5 August 2019

Mr David Gibson
Team Leader - Social Infrastructure Assessments
NSW Department of Planning, Industry and Environment
320 Pitt Street
Sydney NSW 2000

RE: SECTION 4.55(1A) MODIFICATION TO AMEND SSD 14_6848 IN RELATION TO THE STAGE 3B DEVELOPMENT AT LISMORE BASE HOSPITAL

1 Building Elevation - East 3B2
1 : 200

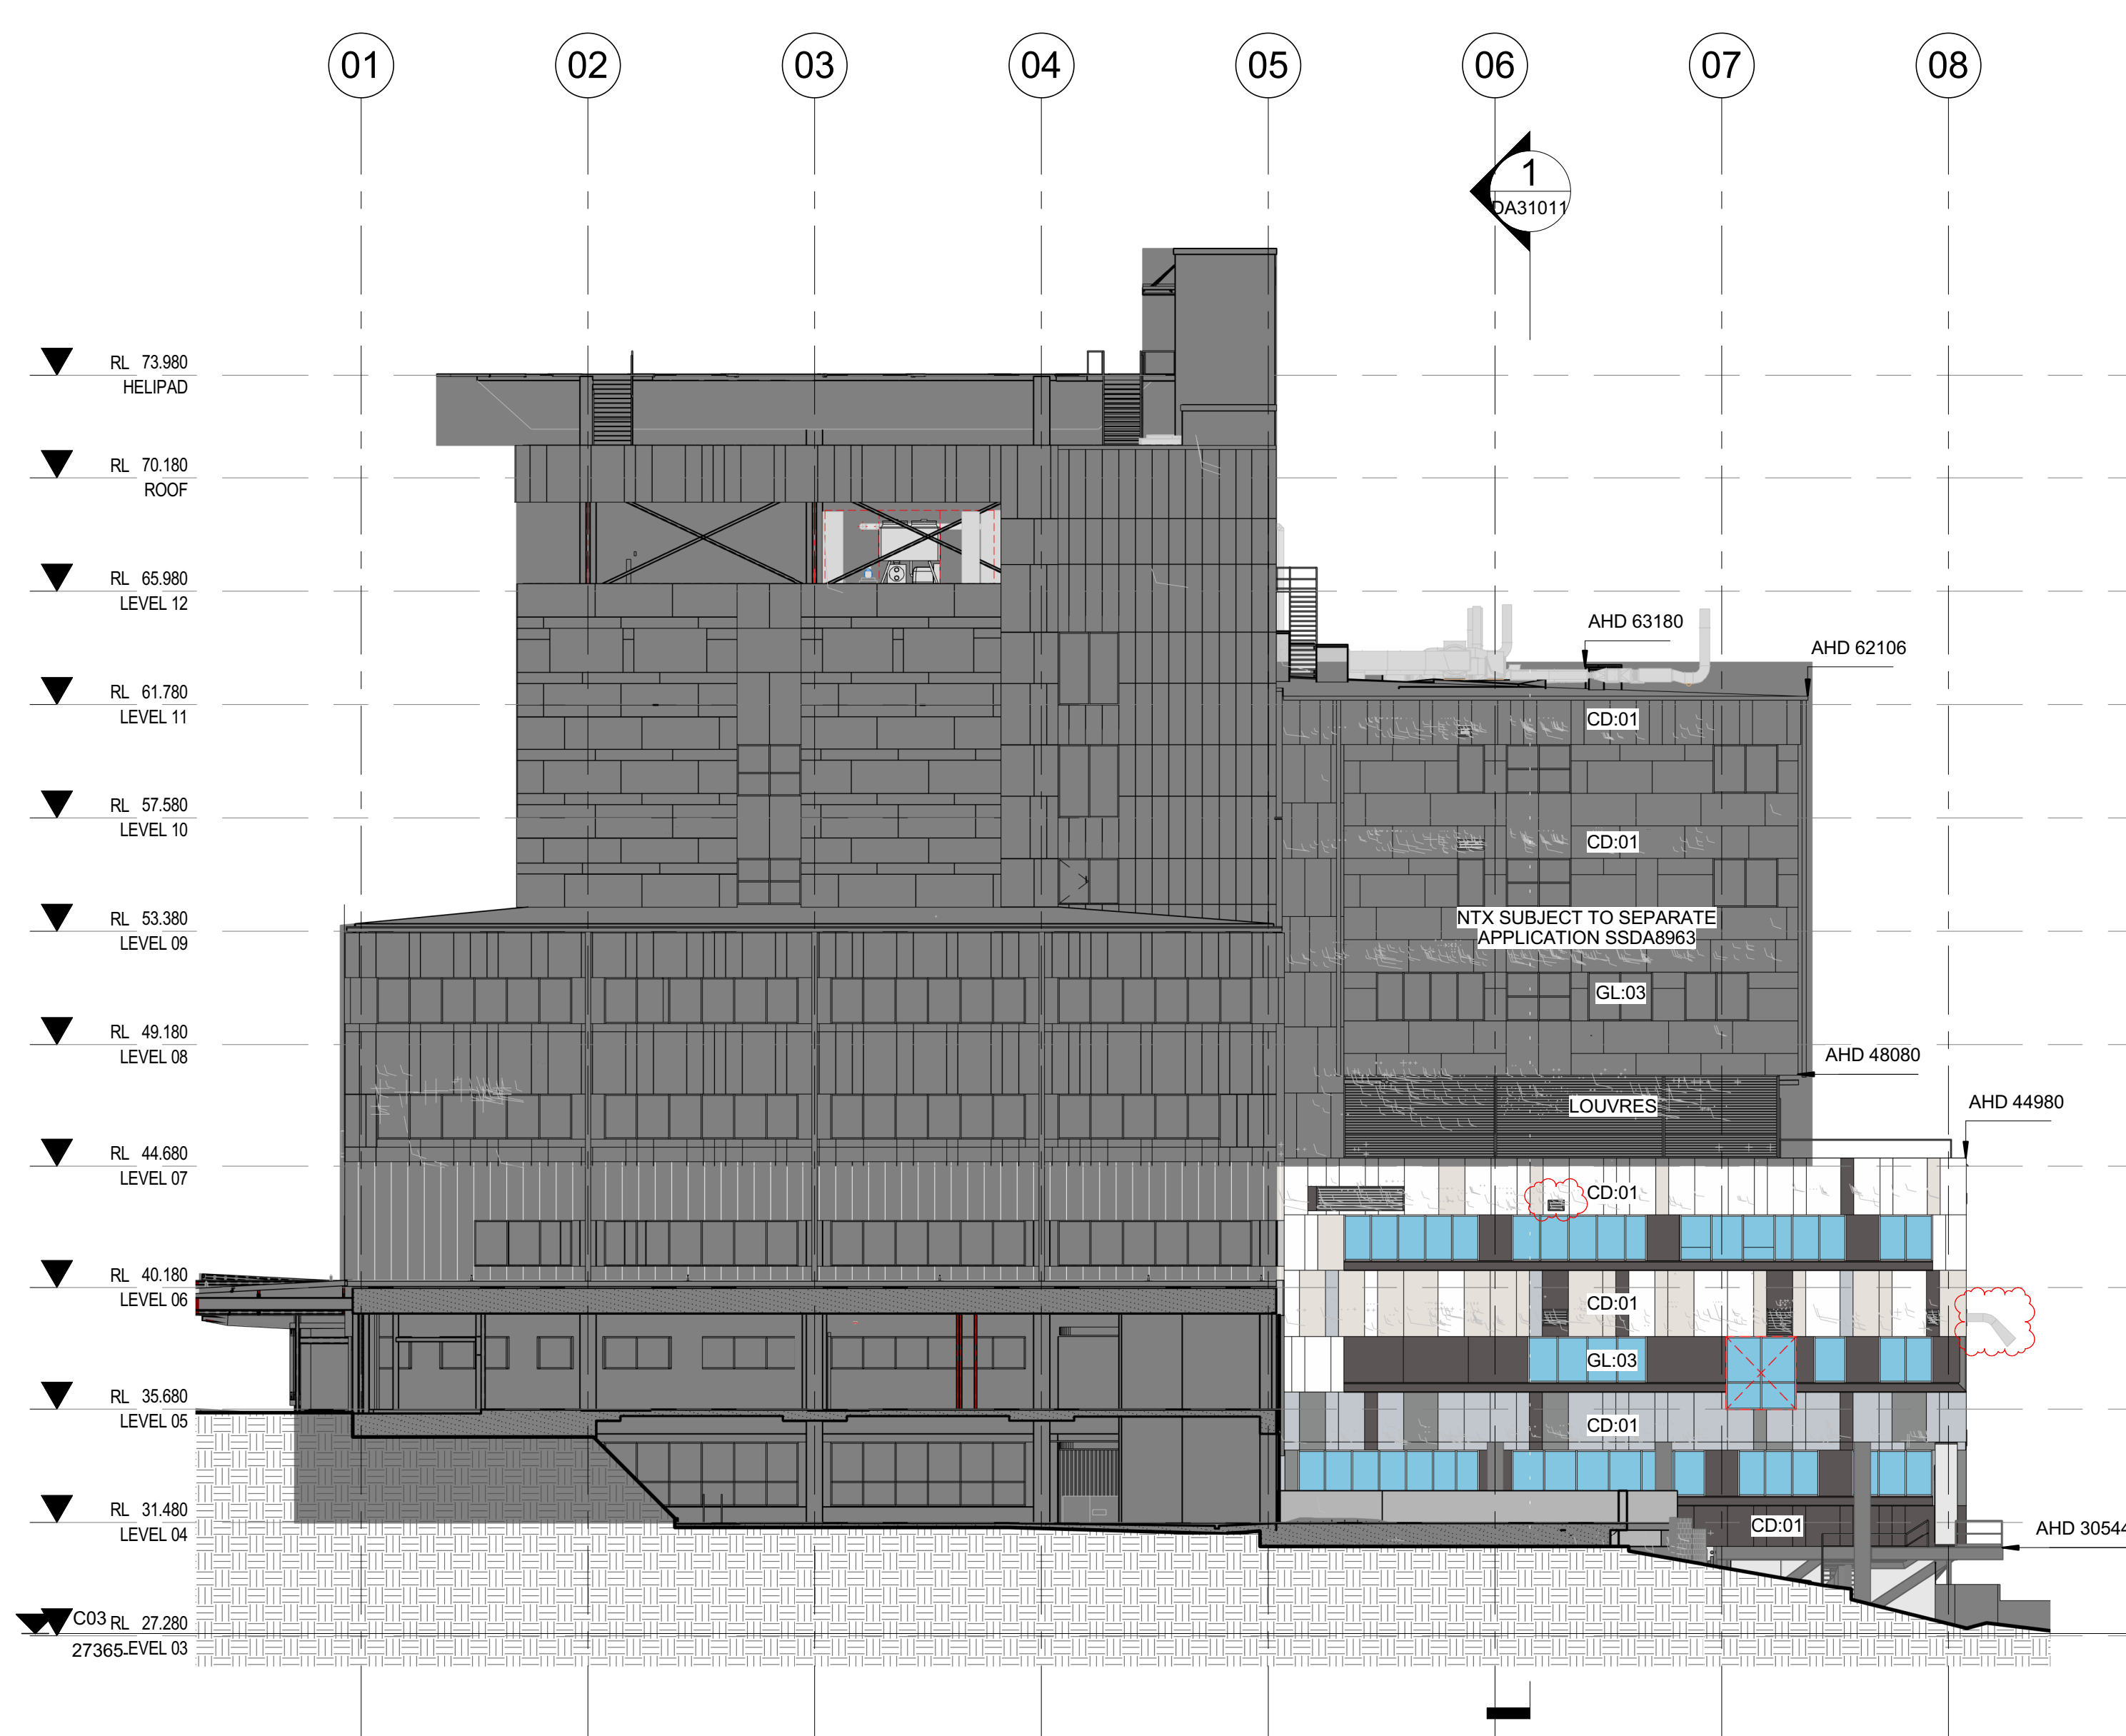
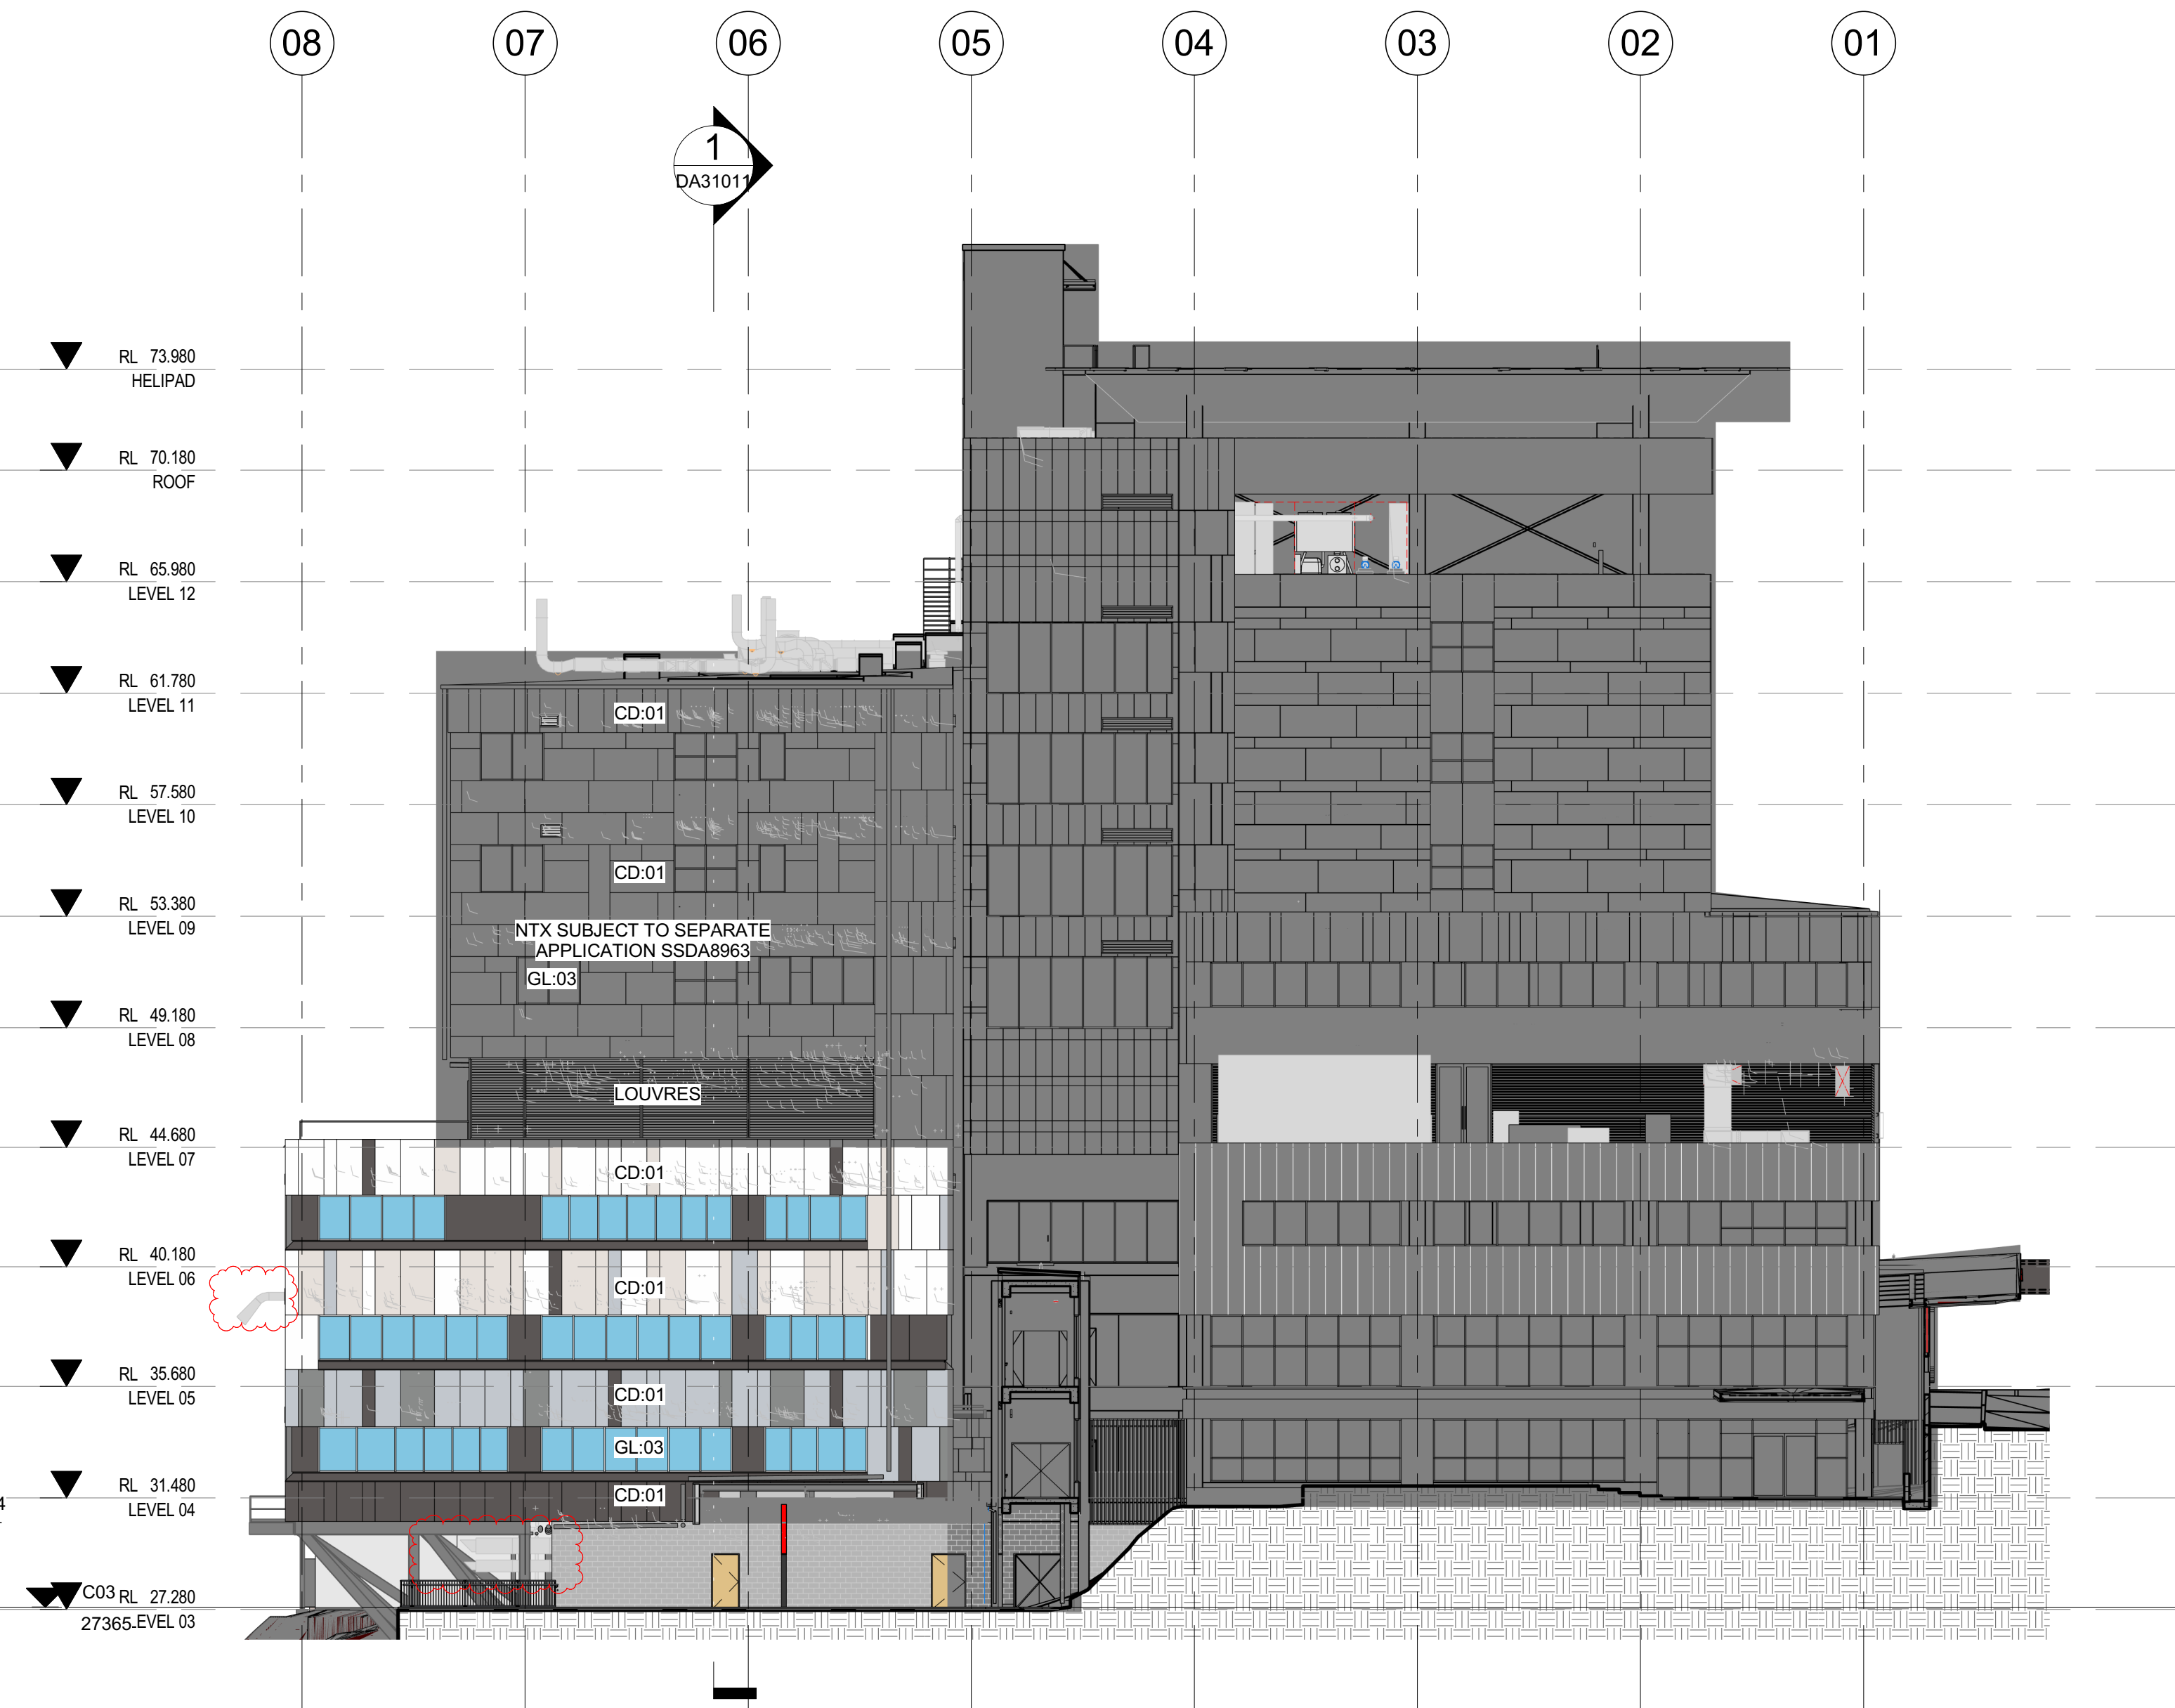
- Eastern and Western Façades: Addition of a mechanical louvre at Level 6 and as above, the quench pipe box location and design has been amended at Level 5, noting it is also visible from both the eastern and western elevations in addition to the northern elevation.
